Your ref: SSD-10425
File no: MC-20-00005

**(SSD10425): Stage 2 – Detailed Development Application - Tallawong Station
Precinct South**

Blacktown City Council's submission to:

1 | SECTION A  
CI-0021 | SCALE 1:100  
PRIVATE ROAD SECTION

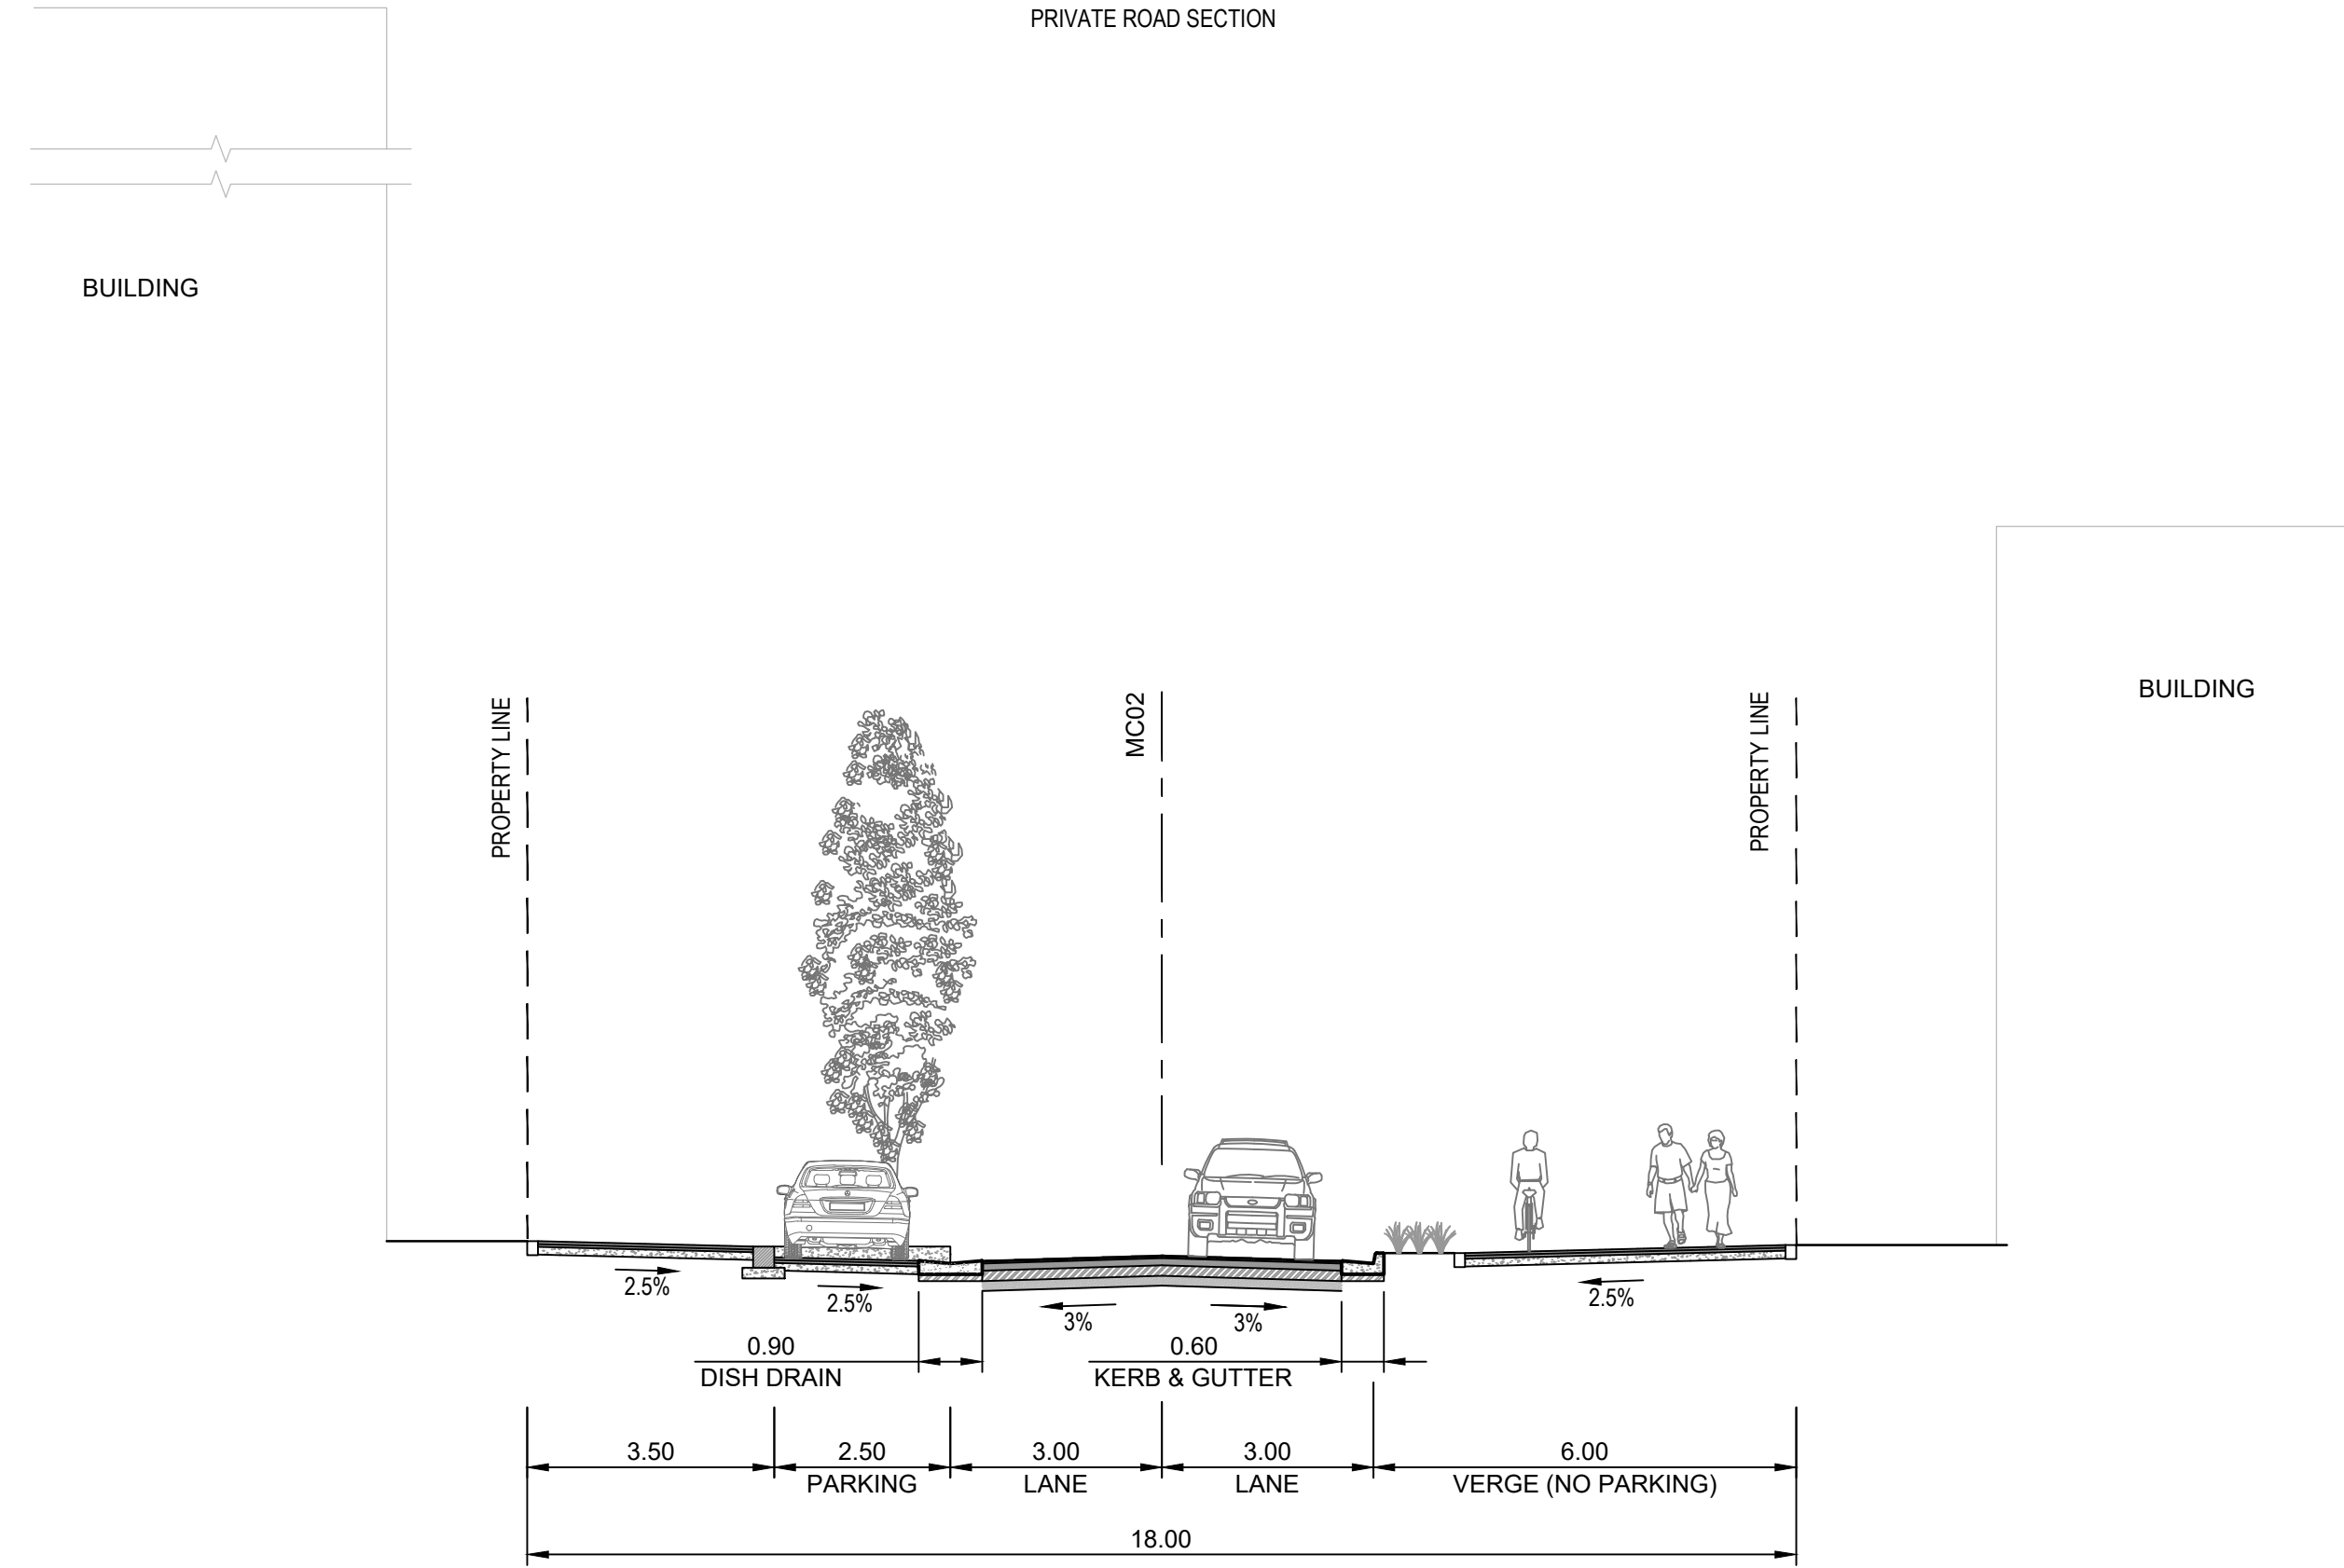
- The proposed development roads do not appear consistent with the relative DCP road design in terms of road formation (note the typical cross-section detail of Local Road Medium-High Density within the BCC GC DCP). Council's Engineering Team may consider the proposed deviation of road formation from the DCP on the basis that the applicant can demonstrate that:

- the minimum width of each travel lane is 3m. This applies to MC01, MC02 and the road to the west of the Park
 - a standard Council waste vehicle can manoeuvre around the proposed bends safely.

- The proposed carriageway configuration of MC01 and MC02 should reflect the requirements of the DCP Local Road Medium Density – i.e. an 18 m road reserve with a configuration 3.5 m verge – 11 m carriageway – 3.5 m verge. Furthermore, the proposed configuration is not in line with the BCC GC DCP typical cross section, and this should be amended to reflect the DCP requirements. Note that a flush transition between carriageway and verge is not supported, and kerb and gutter is required between the carriageway and verge for all roads.

LONGITUDINAL SECTION - MC01  
A1 HORIZONTAL SCALE 1:250  
A1 VERTICAL SCALE 1:25

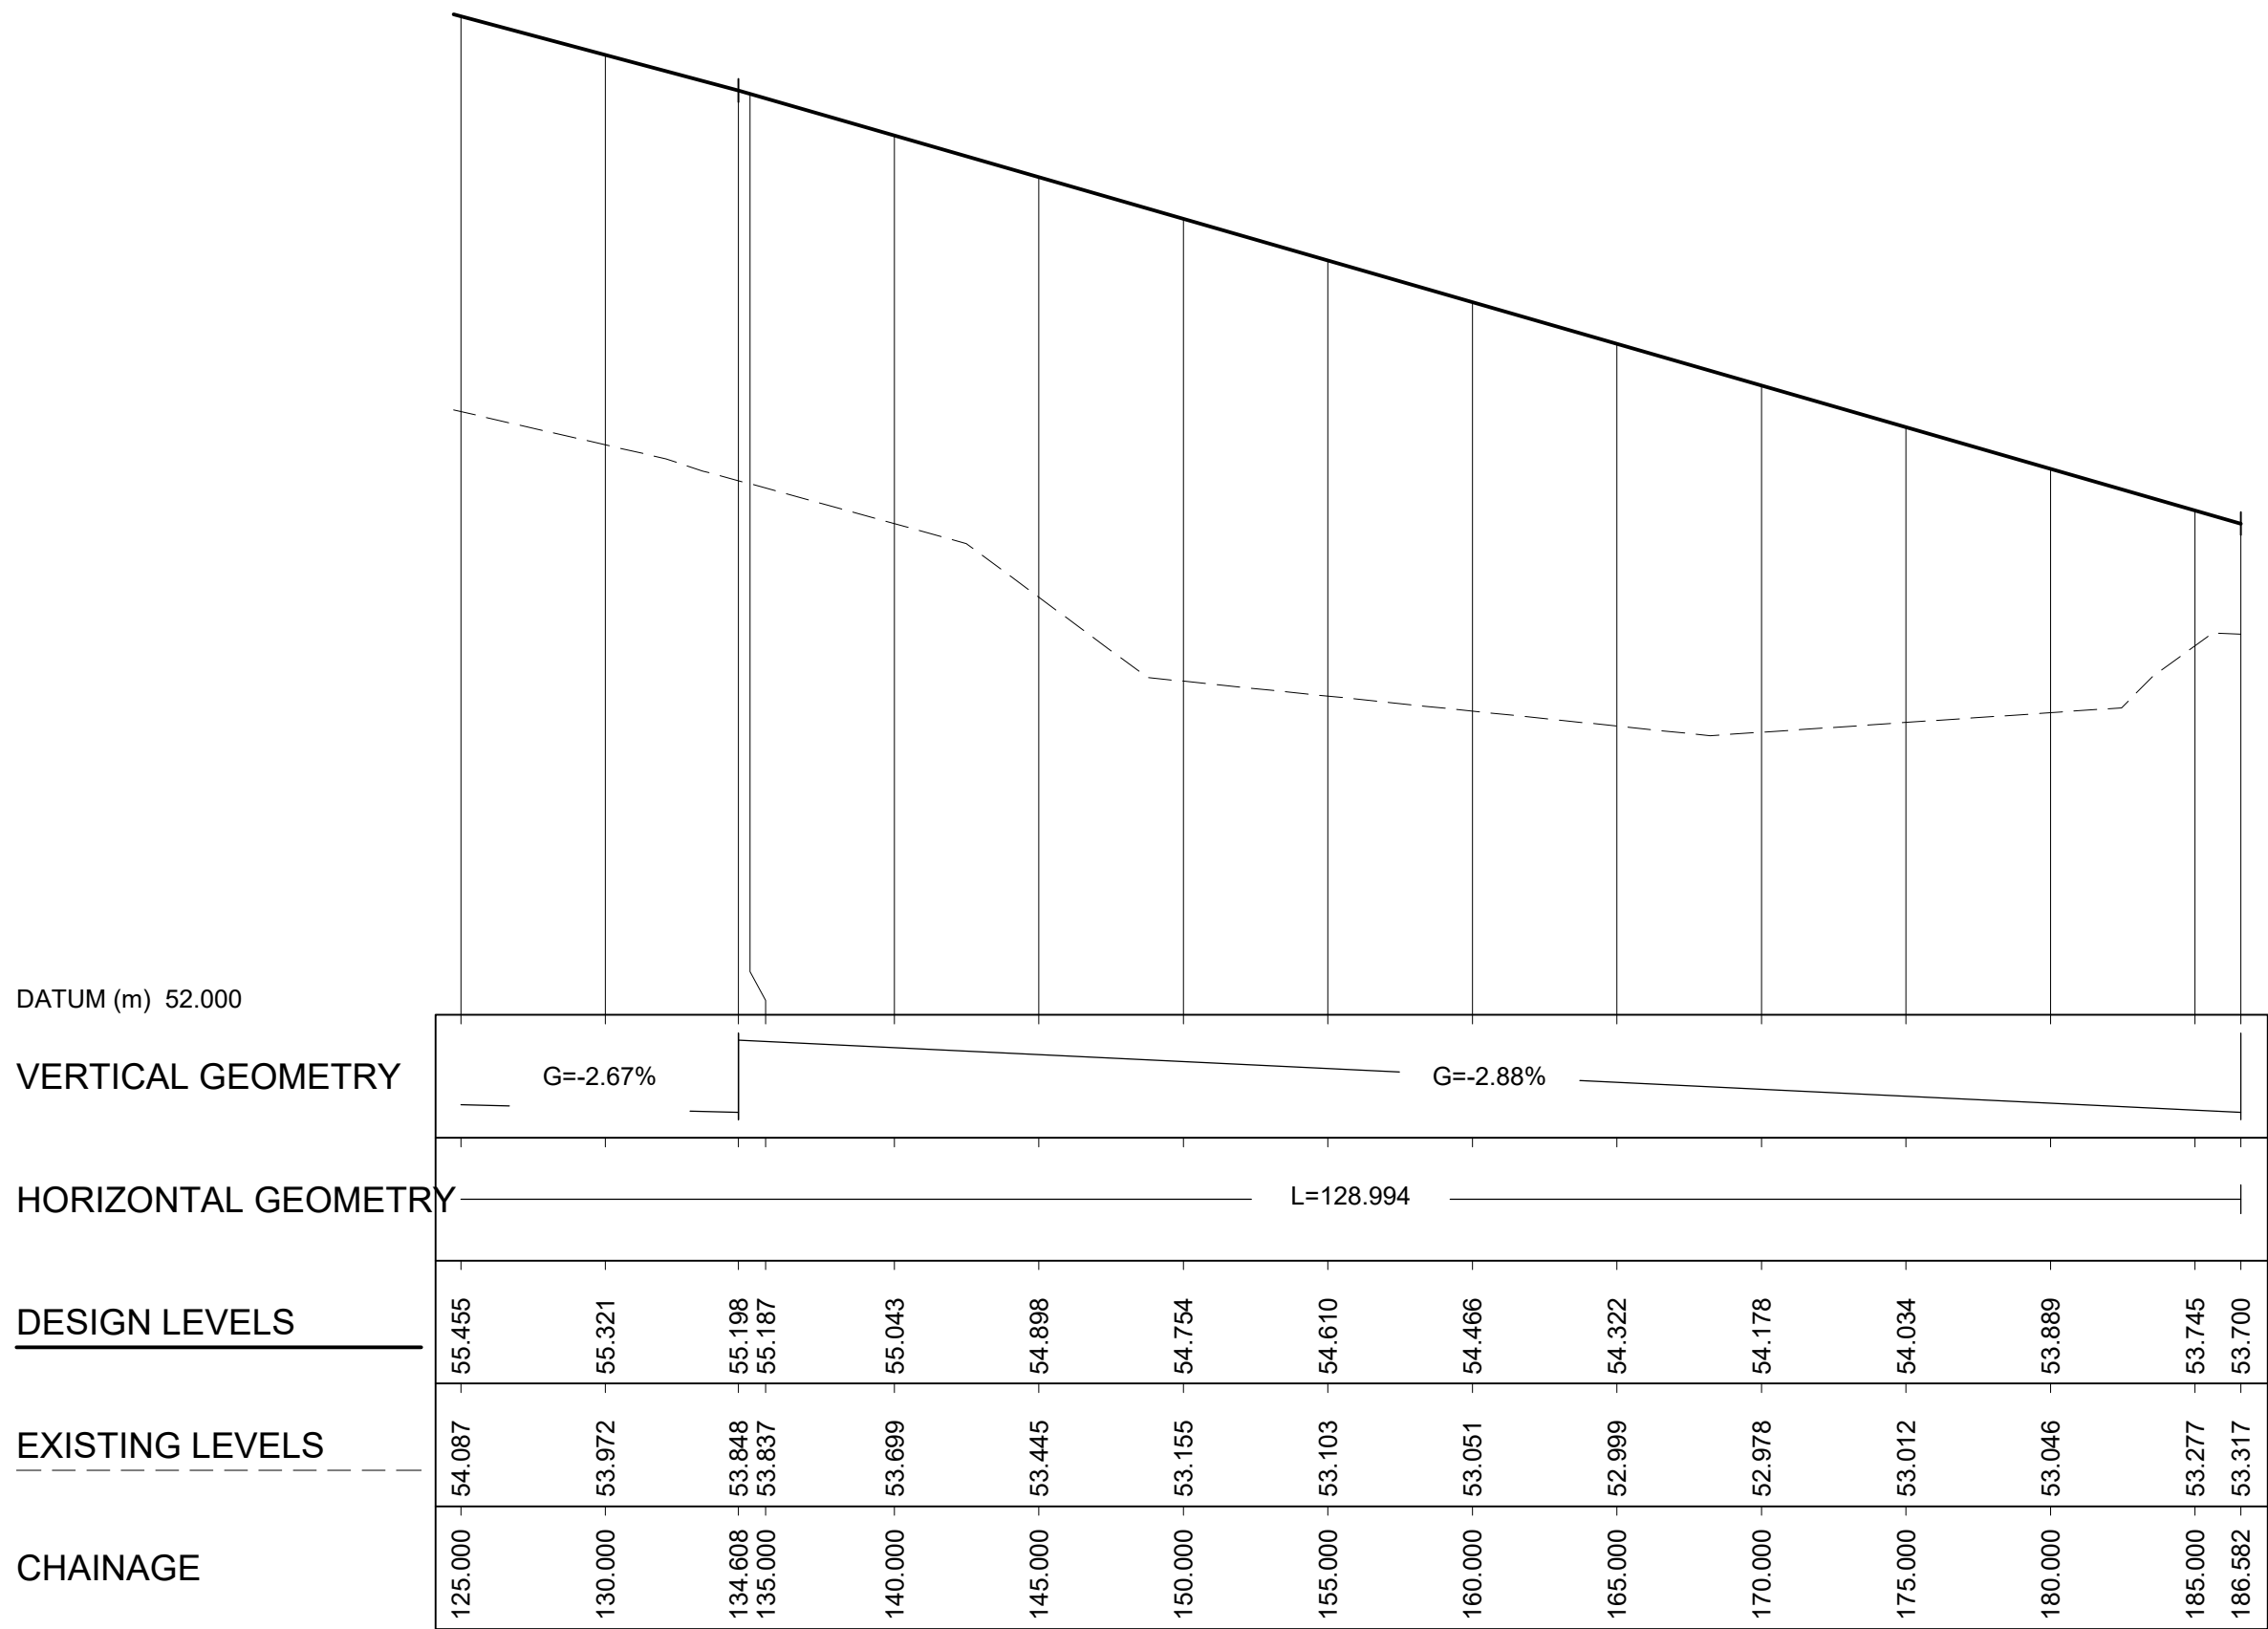
- There appears to be an intentional low point within the internal road MC01/MC02 at chainage approximate 185.00 MC01. The applicant is to demonstrate that the stormwater conveyance of the overland flow path along MC01/MC02 at this point is catered for. The overland flow path is to be reflected on the plan with an associated easement for OLFP.
